**RE: 86-96 MOUNT STREET & 100 MOUNT STREET, NORTH SYDNEY  
SECTION 75W MODIFICATION FOR COMMERCIAL AND RETAIL  
DEVELOPMENT (MP08\_0241 MOD 1) – PART 3A CONSENT**

**REPORT TO THE GENERAL MANAGER**

**ADDRESS/WARD:** 86-96 Mount Street & 100 Mount Street, North Sydney (V)

**PLANS REF:** Drawings numbered DA107 to DA140, dated 12 August 2011, drawn by Skidmore, Owings Merrill LLP and Architectus.

Approved: Ground Floor (Level 6) FFL: 53.85 (Lobby)

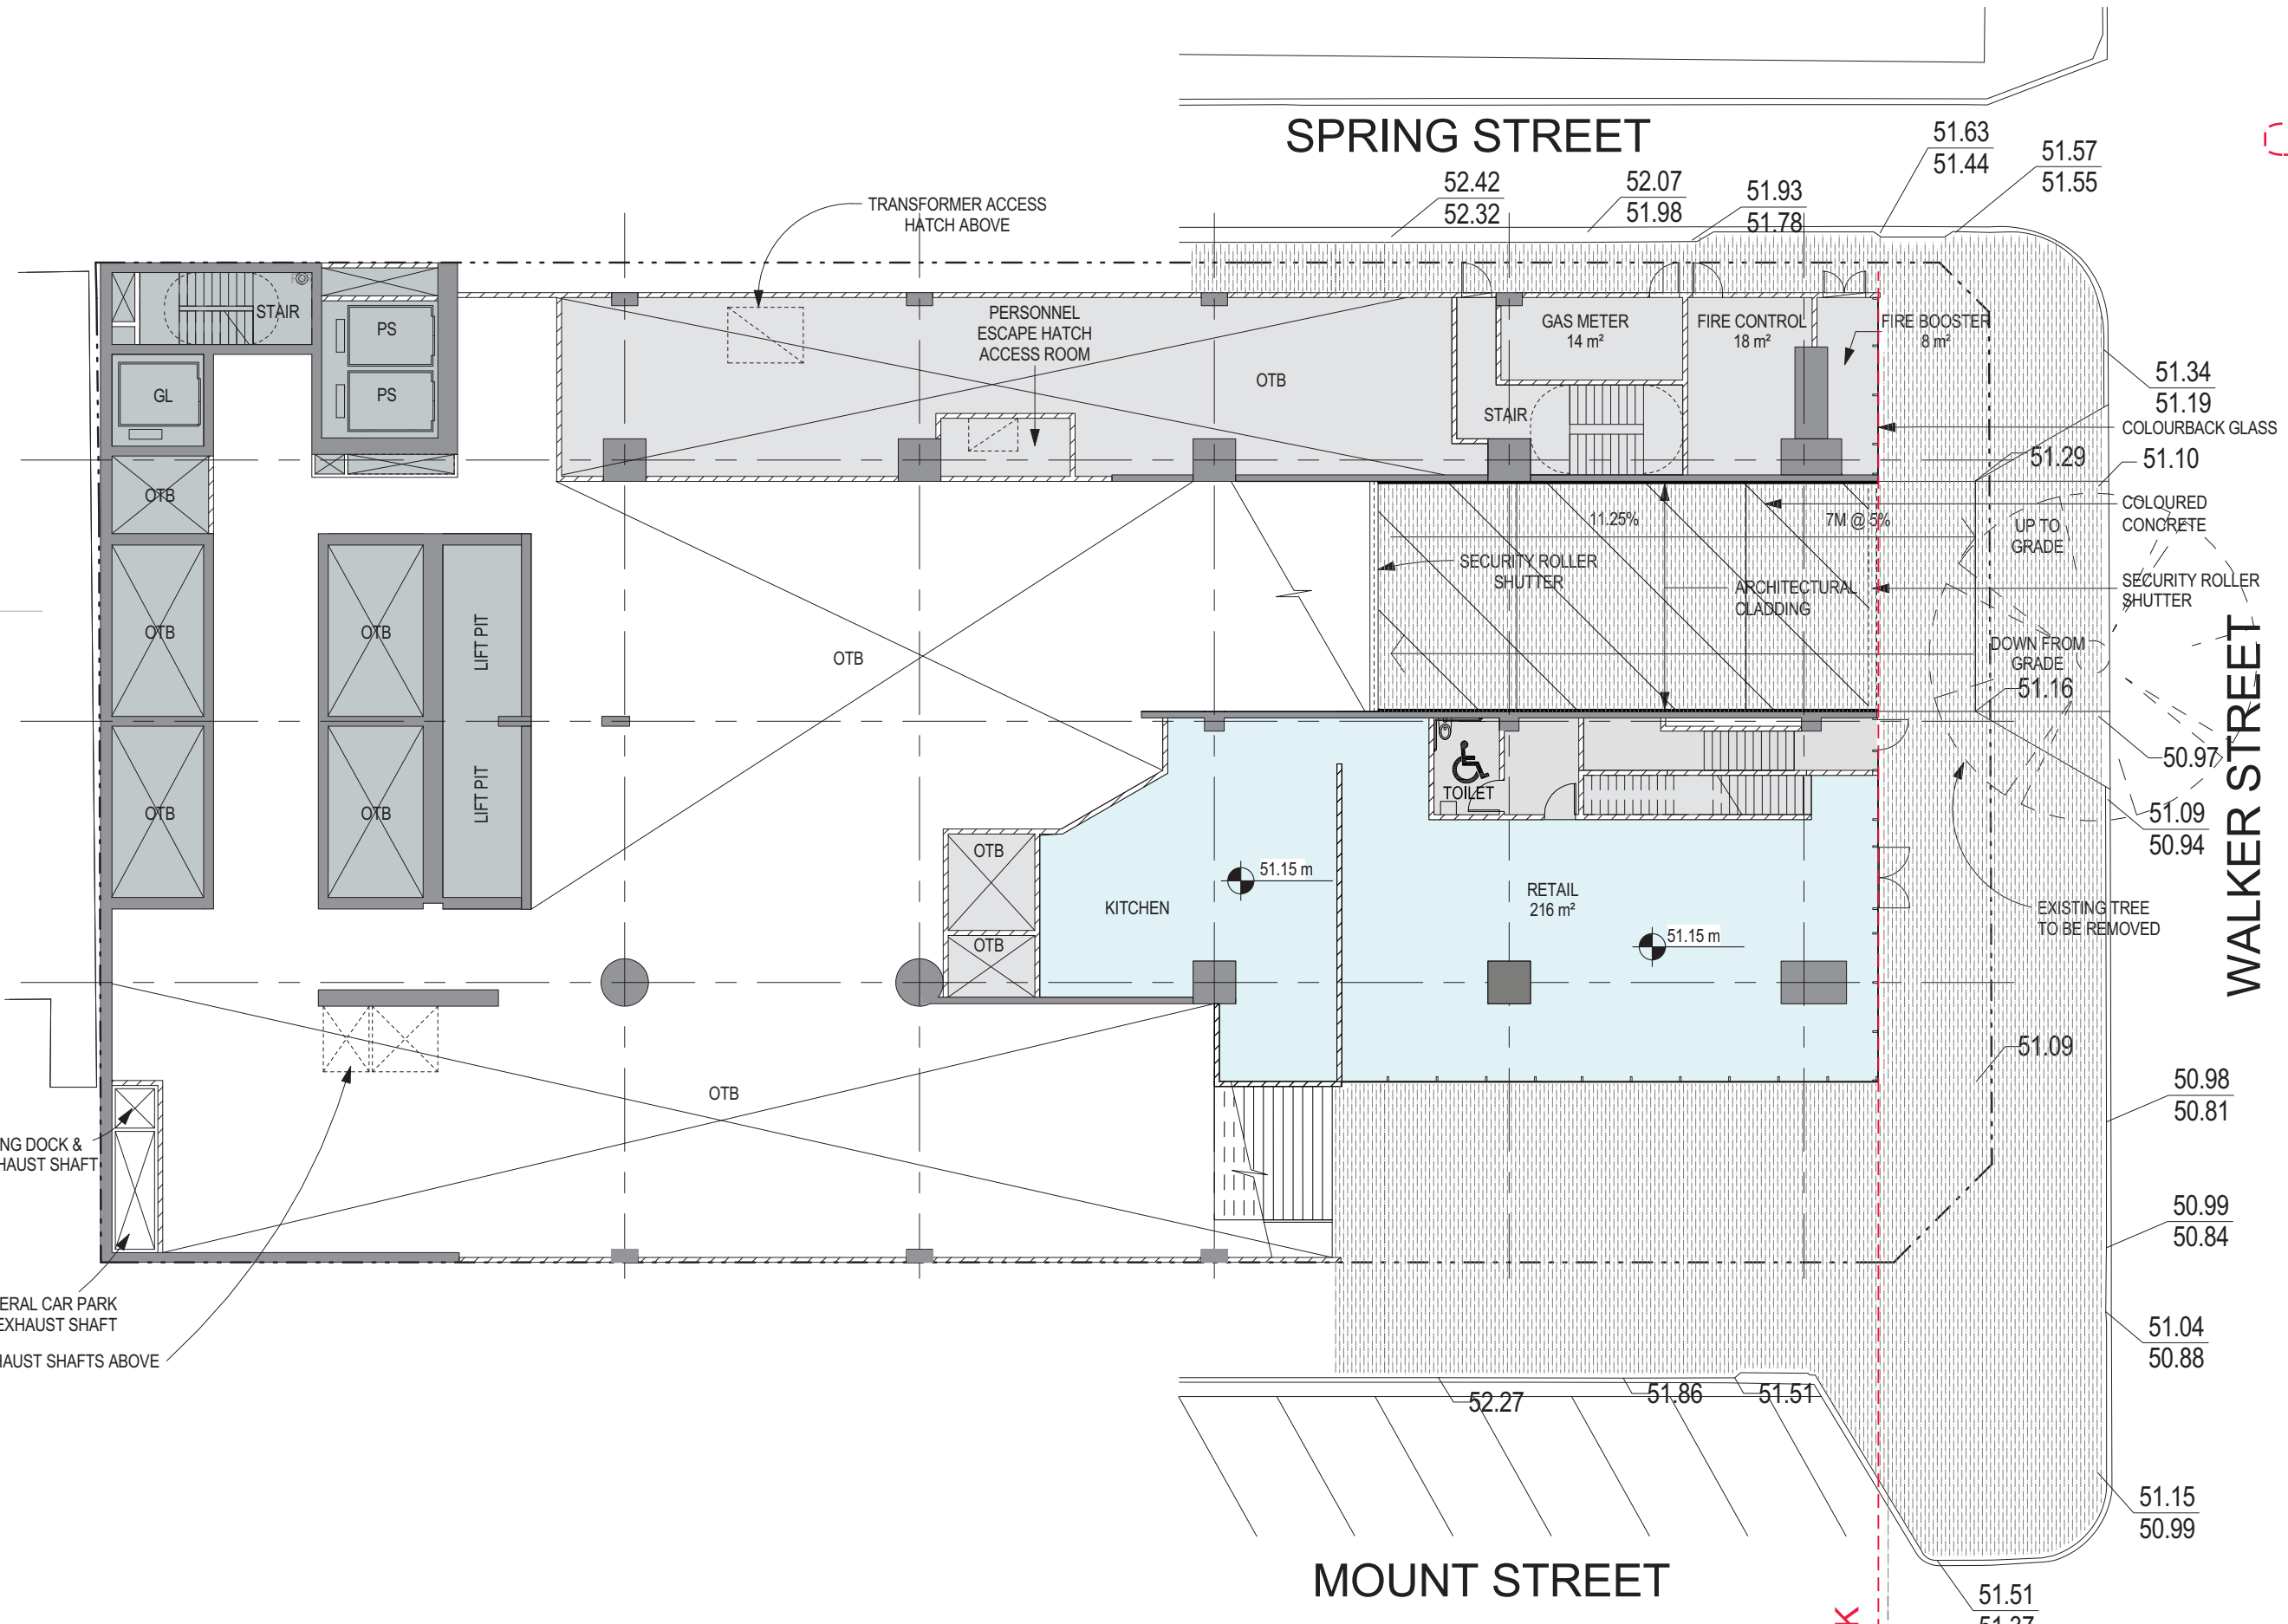
- H. **THAT** the setback on the Mount Street elevation be increased from 4.2m to 4.8m.

*The 3.6m setback from Mount Street is considered inadequate and an additional 1.2m, which would provide a 4.8m total setback is required in order to facilitate improved pedestrian movement on Mount Street.*
